**MODIFICATION REQUEST:
Residential Buildings R8 and R9, Barangaroo South
MP 11_0002 MOD 1**

Secretary's Environmental Assessment Report
Section 75W of the
Environmental Planning and Assessment Act 1979

February 2015

6 ELEVATION Lime Street Shopfront - Type F
1:50

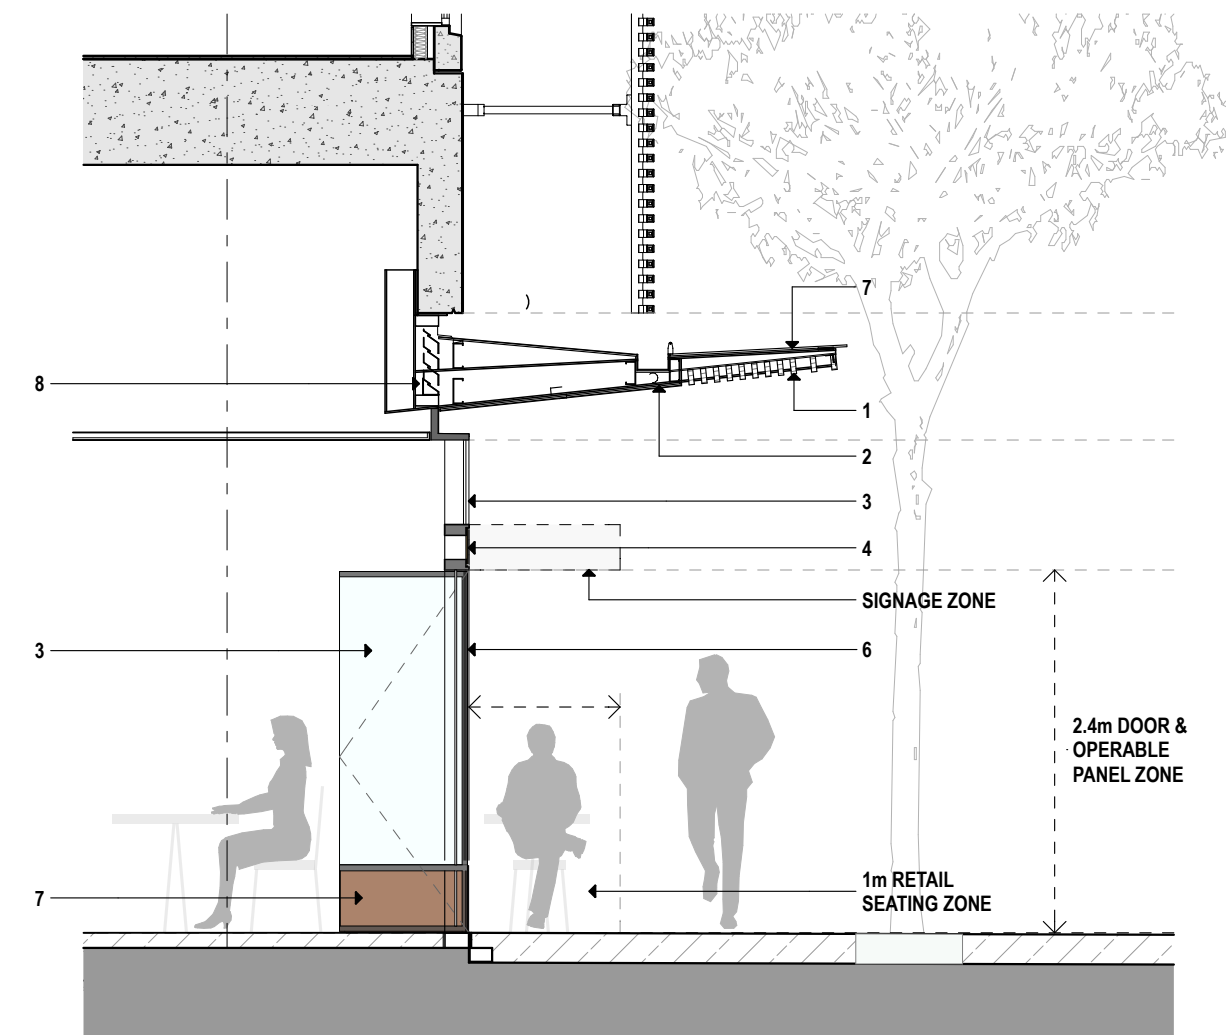
Council raised no objection to the proposed range of retail shop front designs, however, the Government Architect requested further clarification regarding the method for selecting shopfront designs for each of the ground floor retail tenancies. The Department also sought clarification from the Proponent as to whether the retail shop fronts would be constructed under the project approval or as part of the future fit-out applications for the ground floor retail tenancies.

The RTS identified that the retail shop front designs proposed in the modification application are currently only indicative, and that the final detailed designs would be selected by the future tenants according to their design and operational needs. The RTS also identified that the final design of the retail shop fronts would be either undertaken by the Proponent, subject to further approval by the Secretary under the project approval, or the subject of separate future applications by the future tenants themselves. Additionally, the Proponent sought to introduce a new Statement of Commitment (SOC) to secure a framework for the future assessment of the shopfronts for the other elevations (north, south west). The proposed SOC includes general design parameters for each of the shopfronts, namely:

The Department considers that the indicative retail shop front designs with various combinations of glazing and pivot entry and bi-folding doors would generally provide an acceptable outcome for the ground floor retail areas of the buildings fronting Lime Street. The Department also acknowledges the need to provide flexibility for future tenants to tailor the final design of the shop fronts to their needs, and is generally satisfied with the proposed SOC and general design parameters for the shopfronts for the other elevations. Notwithstanding, to provide clarity in the approval, the Department has recommended modifying a number of conditions to specify that no approval is granted to the

1 ELEVATION East Elevation
1:100

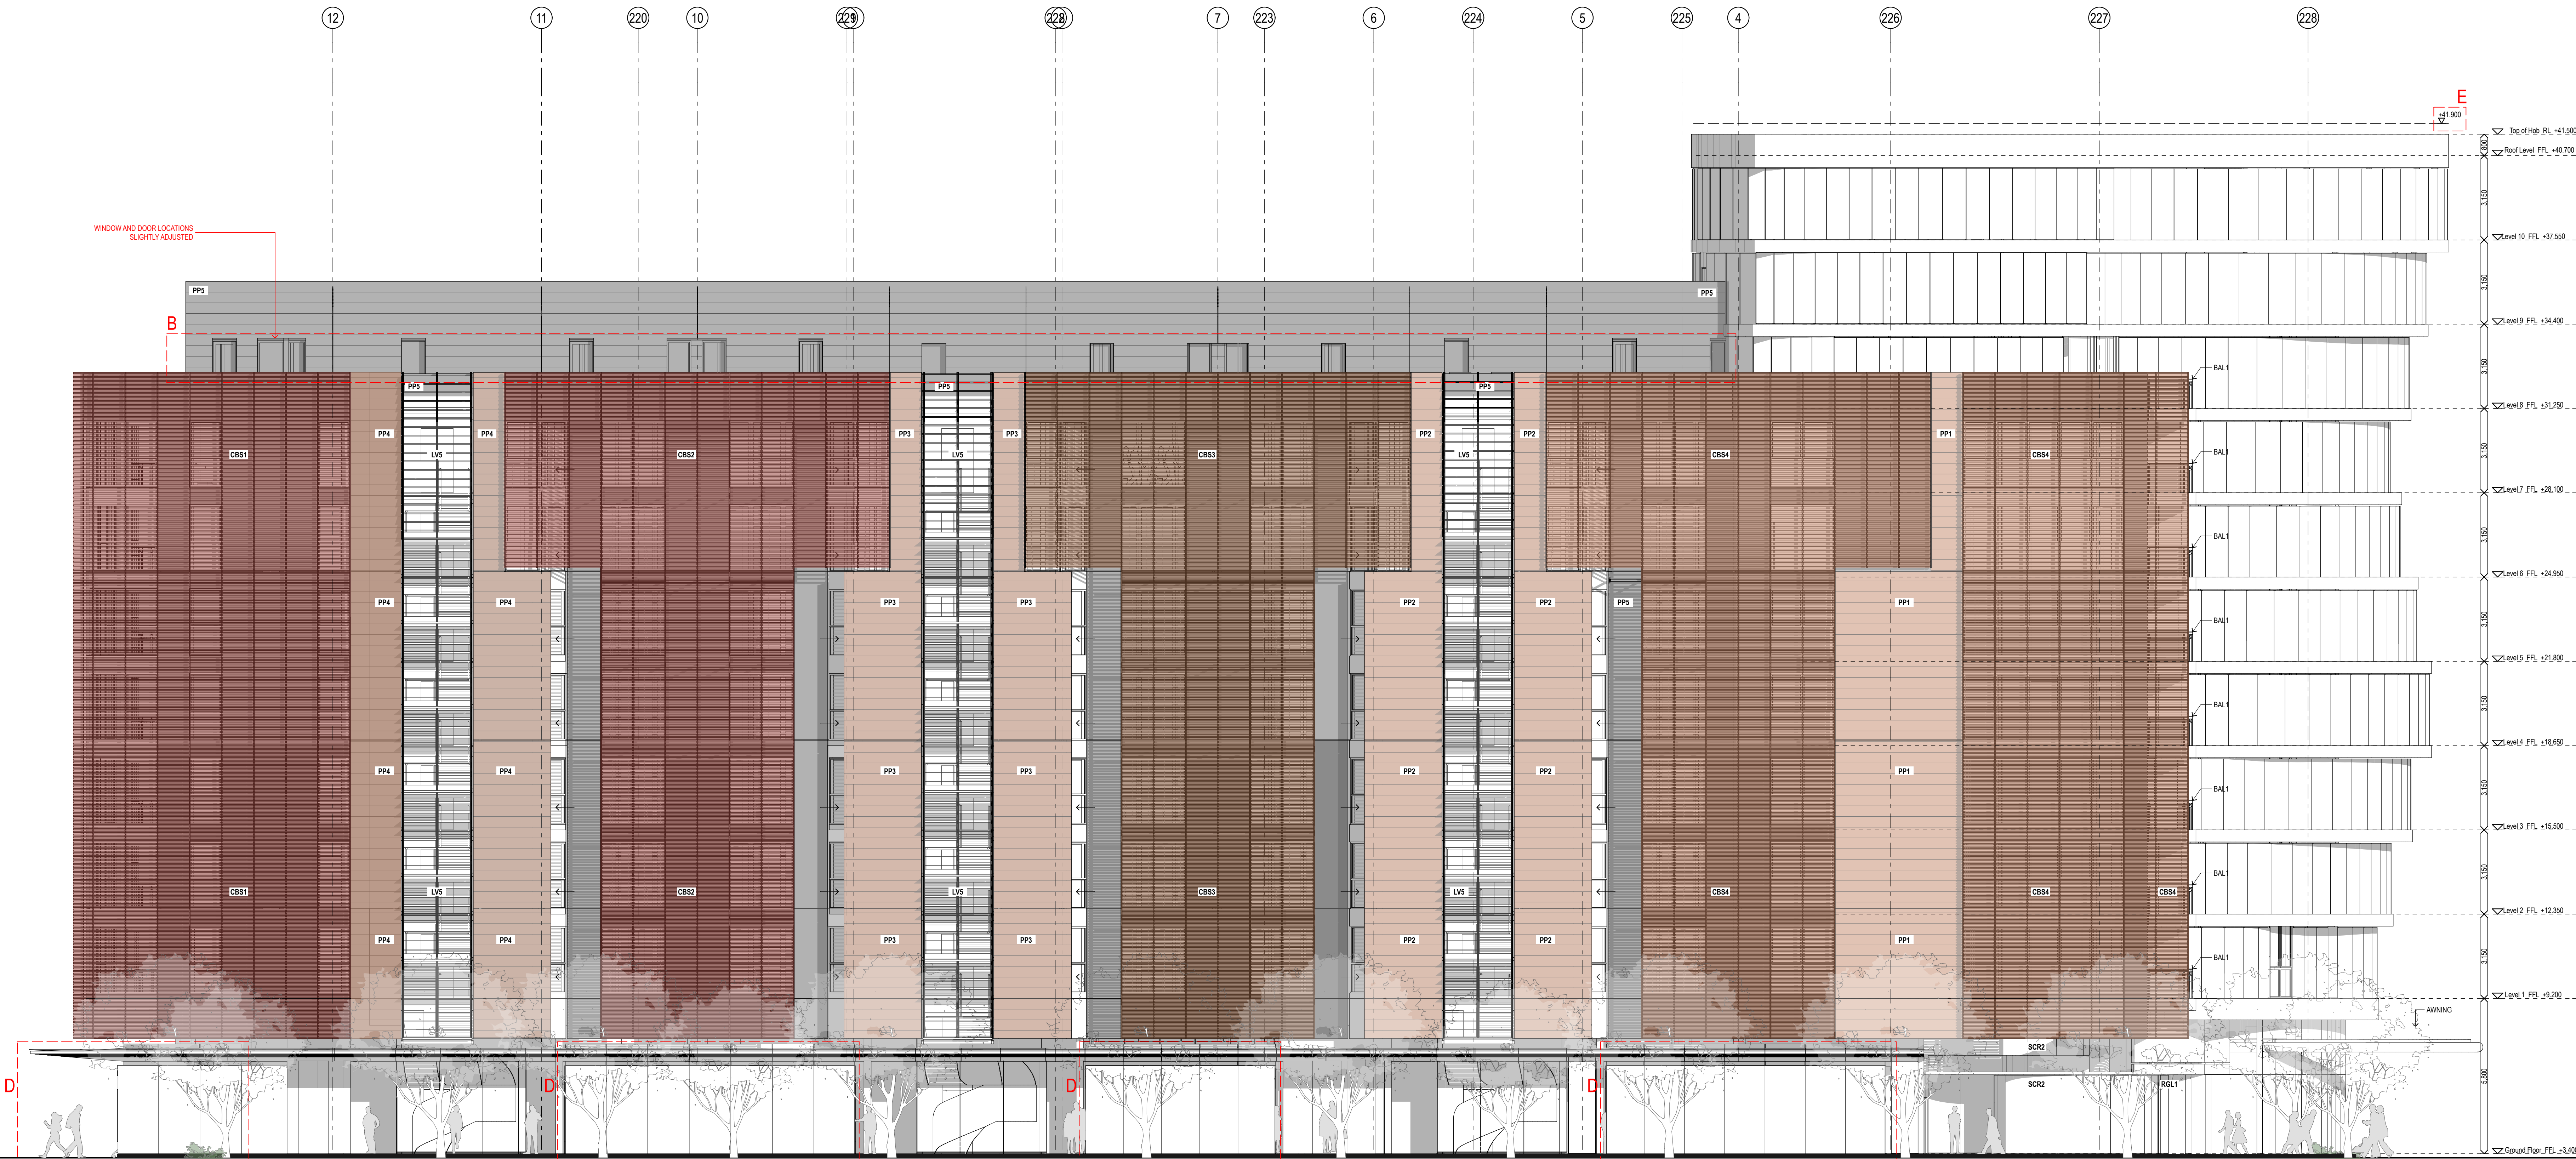
The Government Architect did not support the proposed retractable fabric awnings to building R9 and considered that retractable awnings will impact design excellence, and raised particular concerns regarding the suitability of providing fabric awnings at corner locations. The Government Architect also identified it did not support non-continuous awnings to building R8, and that permanent, continuous footpath protection should be provided in order to promote a high amenity pedestrian environment.

The RTS identified that the proposed retractable fabric awnings to building R9 are intended to soften the strong concrete elements of the design of the building and introduce a more human scale along Lime Street. The awnings would be constructed of high quality durable material to withstand the elements, and the operable awnings would be carefully detailed to be flush with the shopfronts when retracted. The powder coated elements of the awning would match the rest of the shopfront. The RTS also identified that a continuous fixed awning is proposed generally along the entire length of Lime Street which would provide for permanent, continuous footpath protection, which addresses the concerns raised by the Government Architect.

Whilst noting the Government Architect's concerns regarding the retractable fabric awnings, the Department considers that the proposed provision of awnings would generally be an improvement over the existing approved development as they will provide for improved pedestrian amenity and protection. Additionally, the awnings would help to give visual and acoustic separation between the busy public domain and retail activity at ground level, and the residential component of the development immediately above. The Department considers that the retractable awnings, together with the retail shop fronts, residential lobby areas, green walls, and public domain trees and footpaths areas will contribute to a positive pedestrian experience, and that an acceptable outcome can be achieved that will not impact design excellence.

The Department therefore concludes that the proposed awnings are acceptable. Notwithstanding, pursuant to the existing Condition B4 of the approval, the final detailed design of the awnings will be subject to further approval by the Secretary prior to the issue of the relevant construction certificate.
